Permit Number: 040666

This is to certify that C.G.B. Properties LLC/Dwight Brackett has permission to Build 30' x 34' two-story duplex w/2 bulbheads, no porches, no decks AT Carriage Lane (Lot #5) #10 A & B 341-G-025

From: Jay Reynolds
To: Doug Reynolds; James Wolf
Date: Thu, Jun 3, 2004 9:18 AM
Subject: Lot 5, Carnage Lane Review

30 x 40 UNIT
 (FULL BASEMENT)
 LOT 5
 SCHEME 'A'

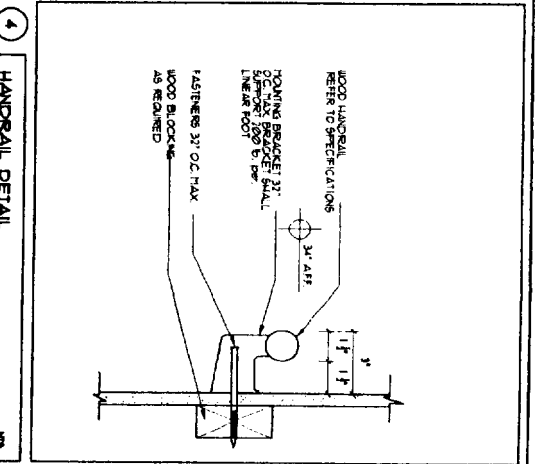
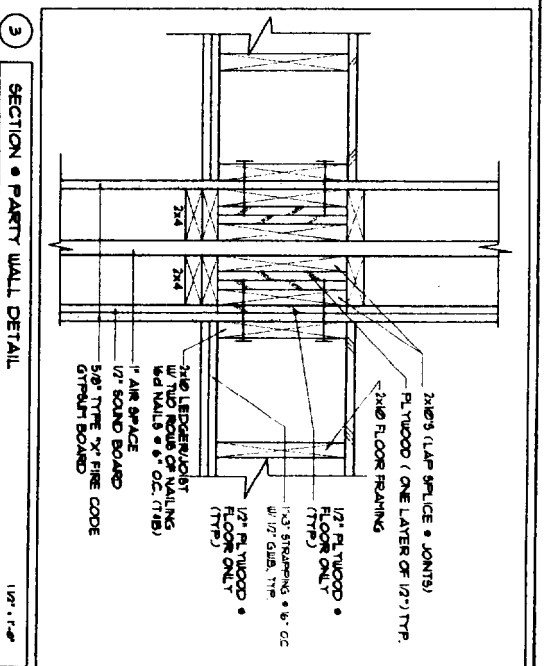
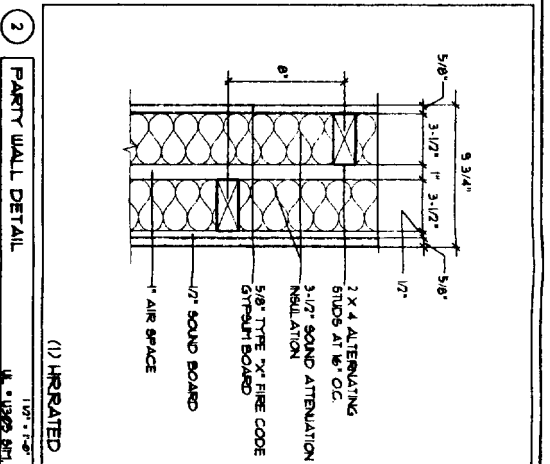
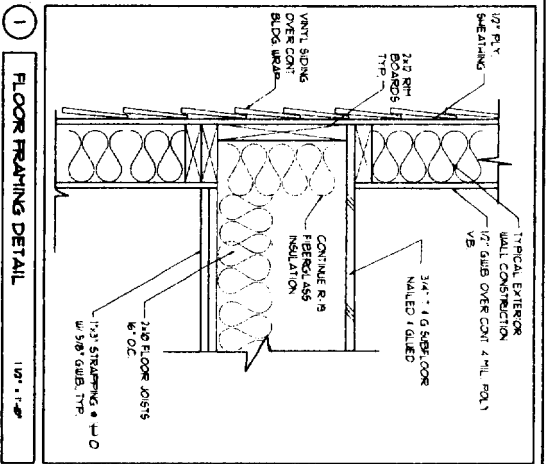
3. The entry ways don't match on the Building elevations and Site plan.
4. The zoning administrator indicated that the rear steps should be shown on the site plan.

Lot 5 Lot Layout and Utility Plan
 CARRIAGE LANE
 Figure No. 1

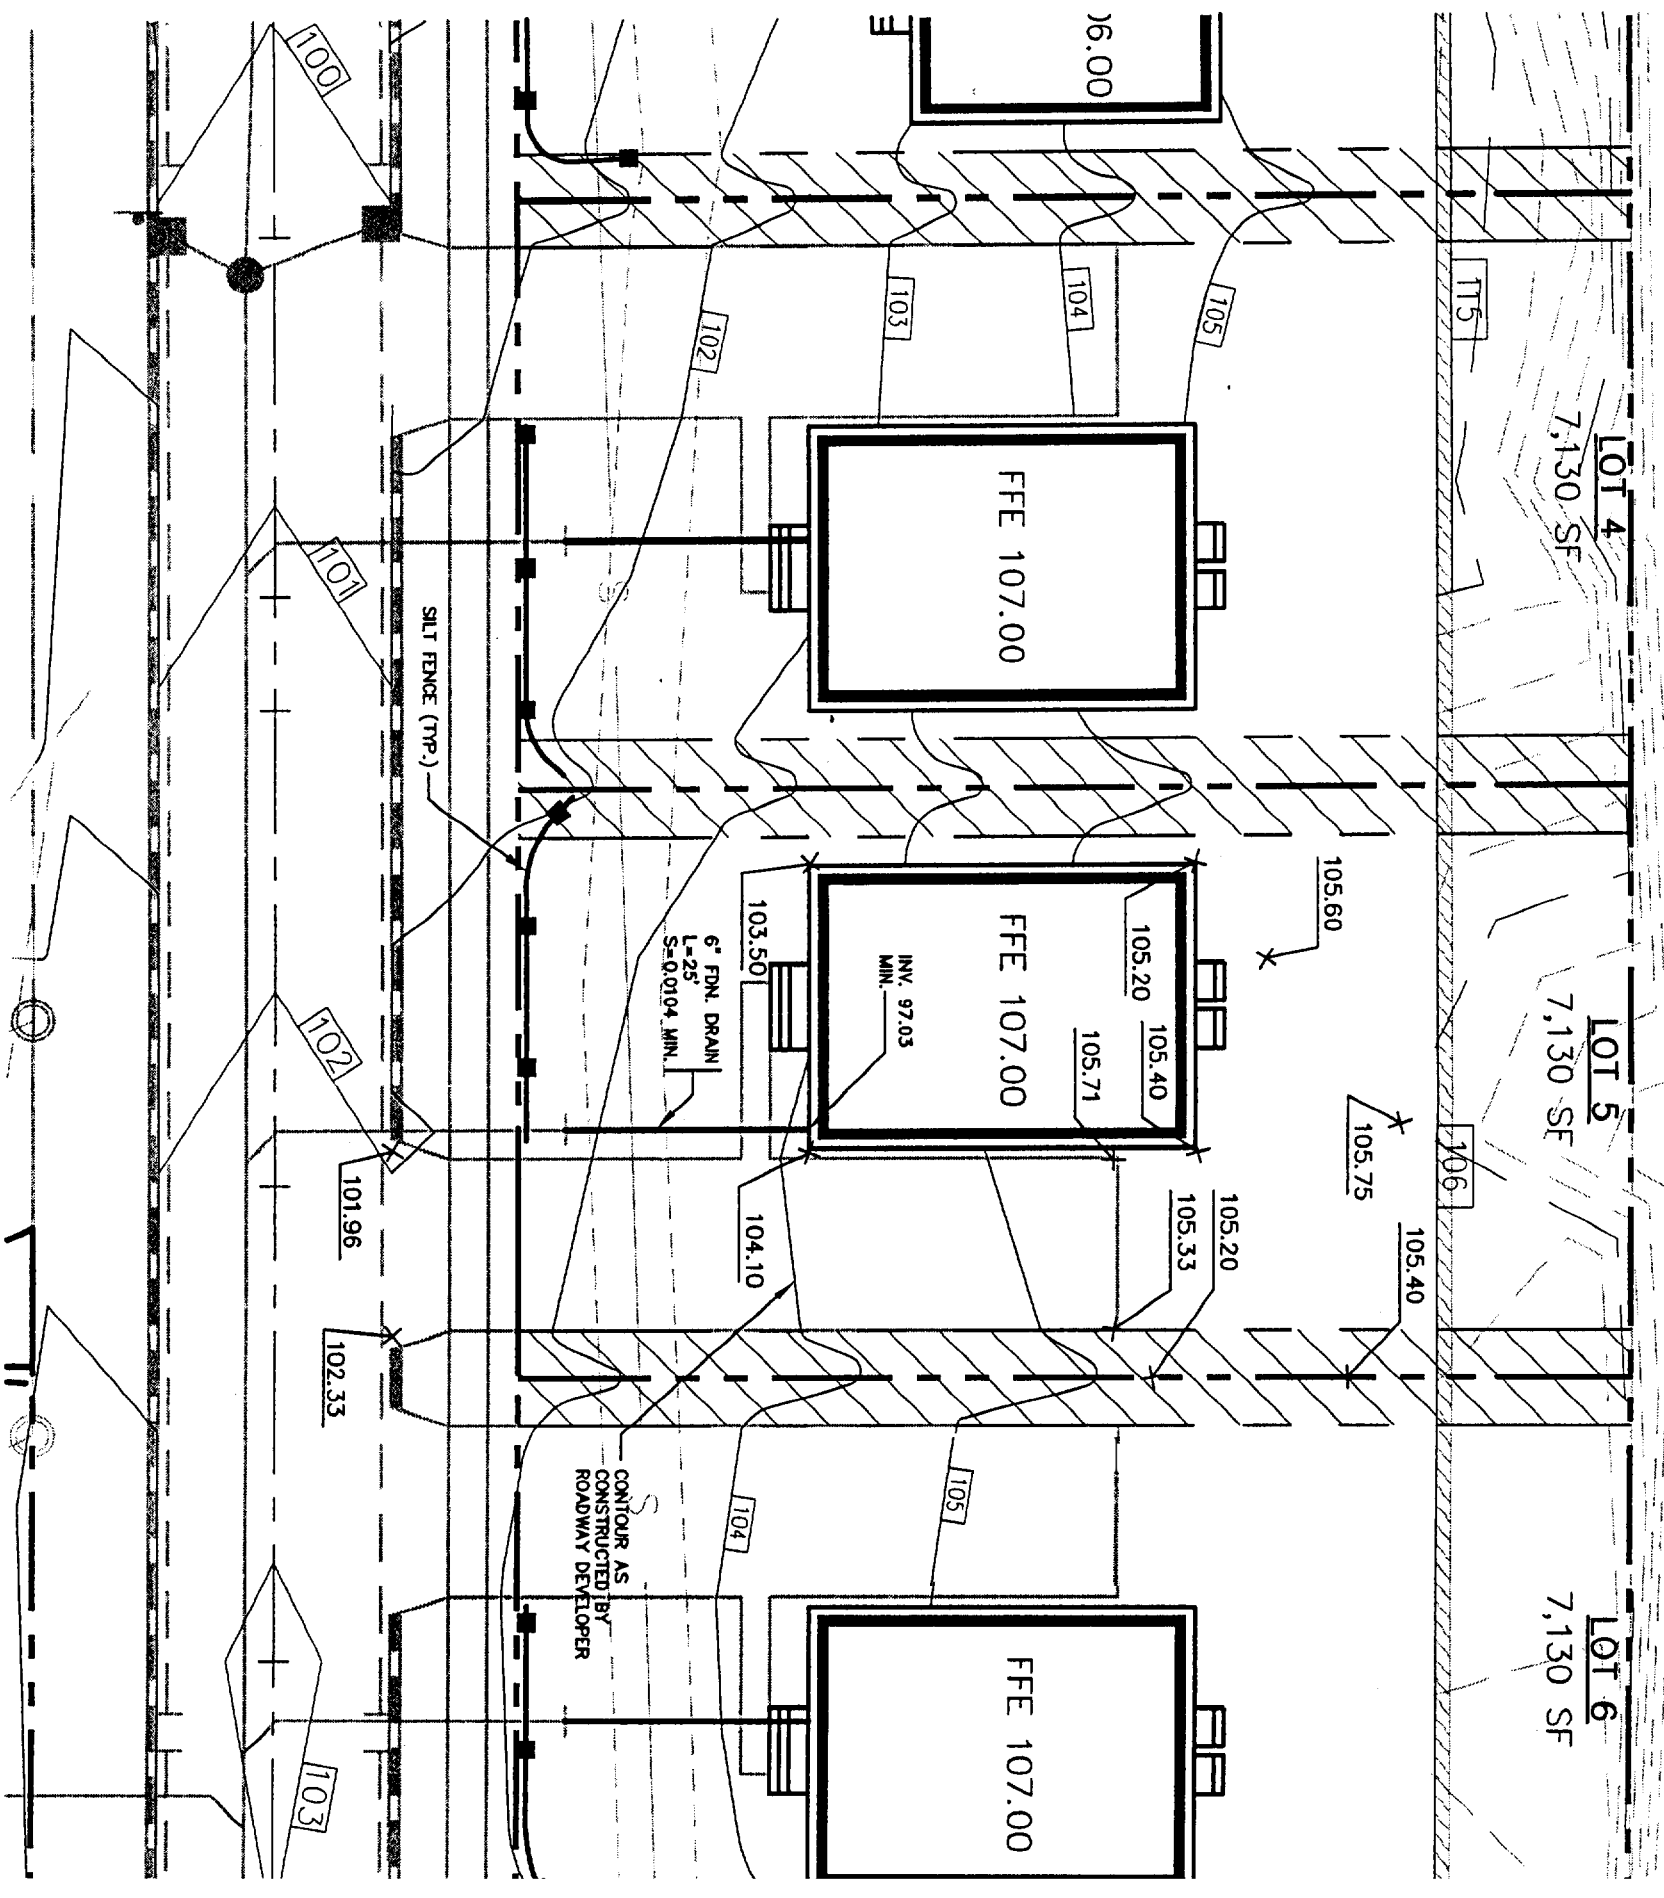
5. Please label the 20' rear setback as the 20' undisturb buffer (as labeled on the subdivision approval).
6. There is a note that says "existing contour prior to construction", which points to contours in the undisturb zone. Being that no changes are allowed in this area, I'm uncertain of the need for this note. Please remove.

7. There is silt fence on the upper part of the lot. I'm unsure how purposeful this will be. Perhaps along the front of the lot (lower) would be more applicable.

8. "3 white pines by roadway developer" note is wrong. These are guaranteed under the site performance guarantee under lot 3. Please correct or remove note.

Drawing Name: **Lot 5 Grading Plan**
 Project: **CARRIAGE LANE**

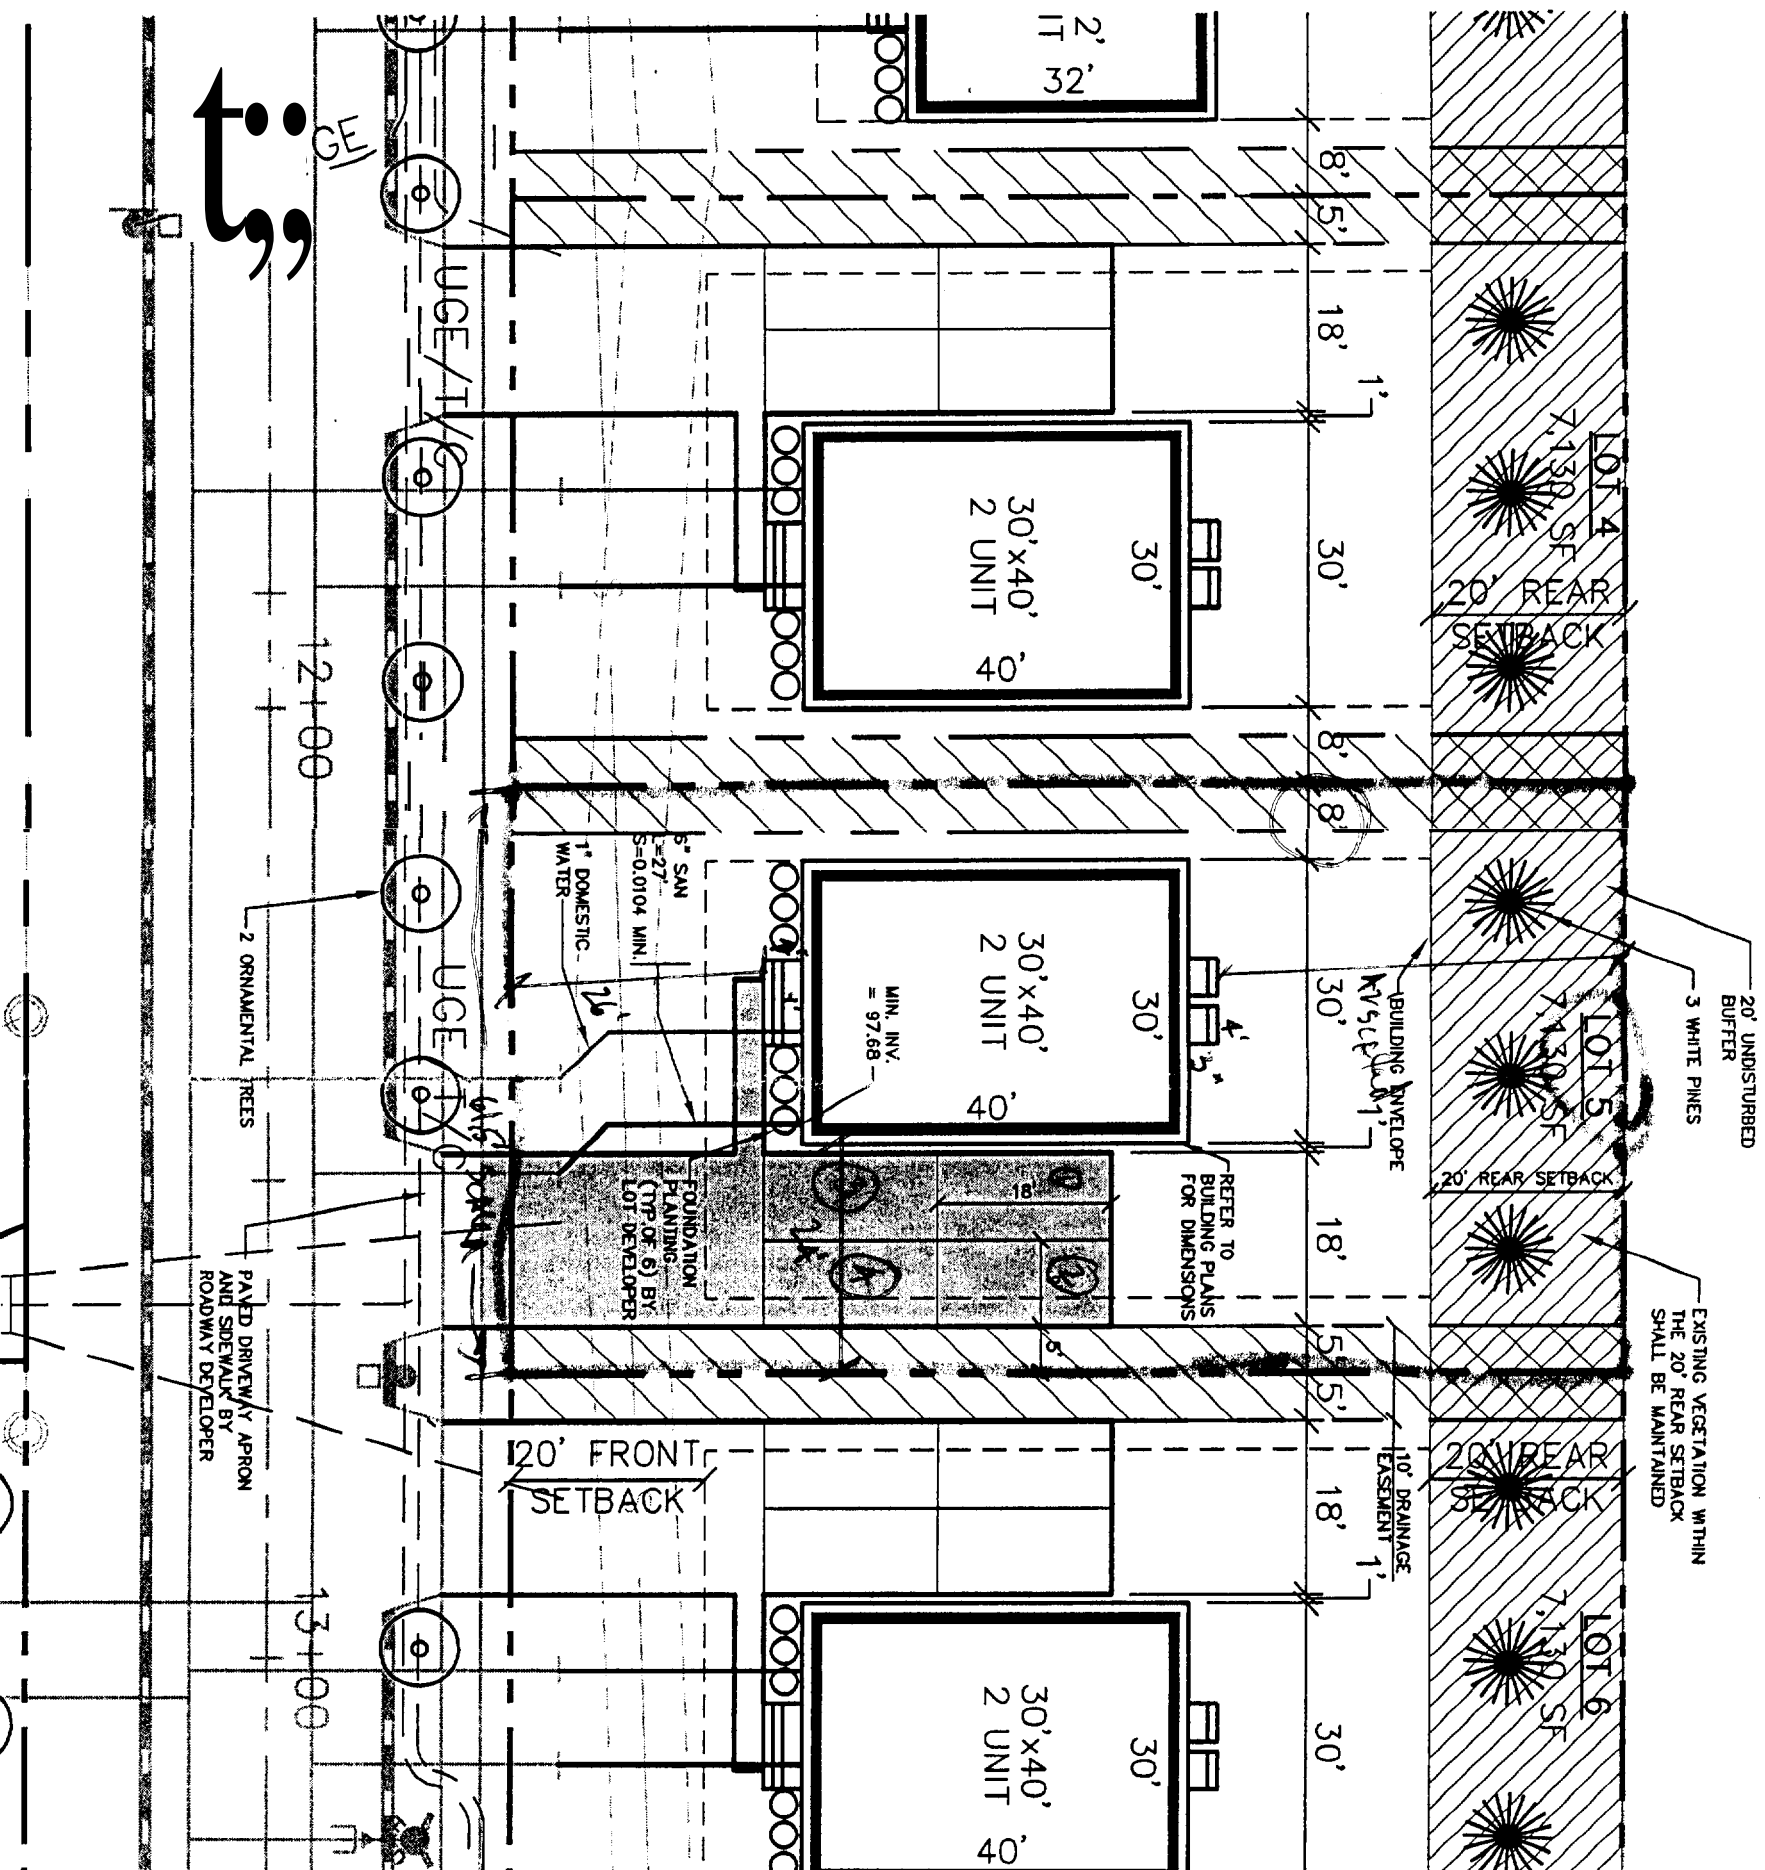
2. It was brought to my attention that the elevation of the bulkheads may be an issue. Being that the elevation is approx. 1.5 feet lower than the top of foundation, either the lot grading or the finish floor elevation may be unattainable. Please elaborate.
